**STATEMENT OF GORDON J AHALT IN OPPOSITION TO THE GRANTING OF A REASONABLE USE
EXCEPTION IN CASE CA015-001 7 VAR18-002**

JULY 26, 2020

Rebuttal to July 17, 2020 letter submitted by George Steirer to the Hearing Examiner:

<p>THE HEALEY ALLIANCE AZ 2505 N 25th DRIVE, GOODYEAR, AZ 85526 • (480) 444-6766 ARCHITECTS</p>	<p>Mi Treshouse, LLC, 5631 EAST MERCER WAY MERCER ISLAND, WA.</p>	<p>SITE PLAN DATE: 03/20/24 DRAWN BY: [Name] CHECKED BY: [Name] SCALE: 1" = 20'</p>
--	---	--	--

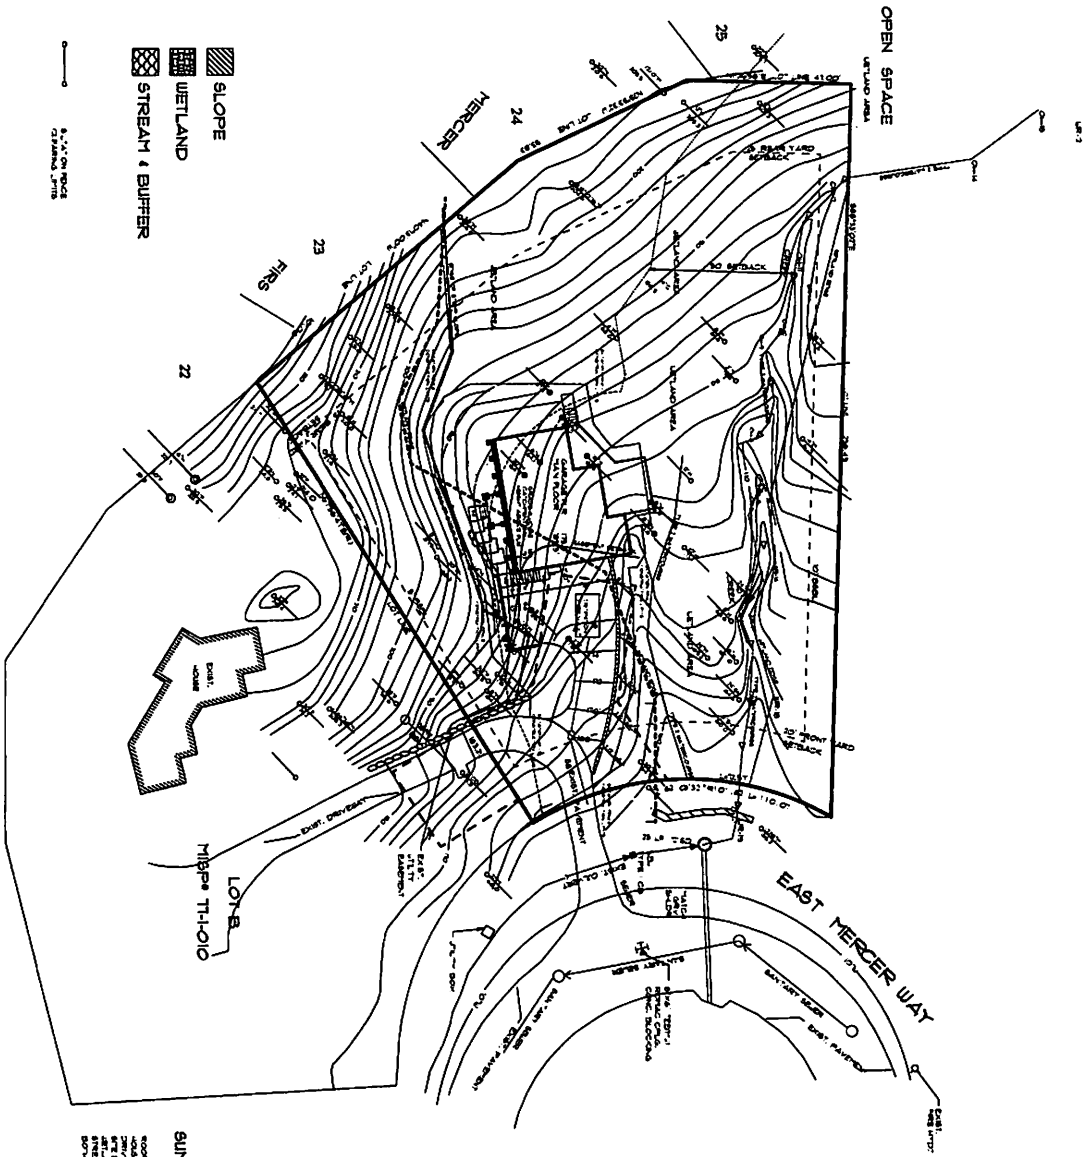
Therefore, if the Applicant's RUE application is now governed under the newer City Code then Treehouse must submit a survey of the site. We have not seen a site survey submitted as an exhibit. This is specifically critical to locating the southern Type II Watercourse on the site and relative to the location of the proposed home foundation. In my opposition letter submitted to the Hearing Examiner July 20, 2020 (Exh. 72), I included exhibits that show the southern Type II Watercourse was relocated approximately 25' northward and further away from the proposed home foundation after the prior site plan dated May 25, 2018. Attached is the City of Mercer Island GIS Portal showing the location of the southern Type II Watercourse. As I have explained, the southern Type II Watercourse follows the "V" in the contour lines in the May 25, 2018 site plan and in the attached MI GIS Portal map. The current site plan submitted by the applicant shows the southern Type II Watercourse located further north and along the ridgeline that separates the 2 Type II Watercourses on the property.

My visual inspection of the southern Type II Watercourse says the Watercourse follows a fairly straight line and does not bend to the north as shows on the current site plan, and I can see there is no elevation south of the stream that is lower than the stream itself, which would not be the case in the depiction shown on the current site plan.

It is reasonable and required that a survey show the location of both Type II Watercourses and a survey has not been submitted. Only a depiction by the architect on a site plan has been submitted.

If I am correct, then Mr. Steirer's statement in **5. K.** is incorrect as the foundation of the house will actually be located in the southern Type II Watercourse or extremely close to it which is not "minimizing impacts to critical areas and buffers to the greatest extent feasible" as stated in **5.K.**

A survey should also delineate the wetland boundary rather than relying on the architect's depiction of the wetland. The site plan shows the wetland boundary as having very sharp angles along the southern edge which is far from accurate and very different than the wetland boundary shown on the CHS surveys up to and prior to May 2018.
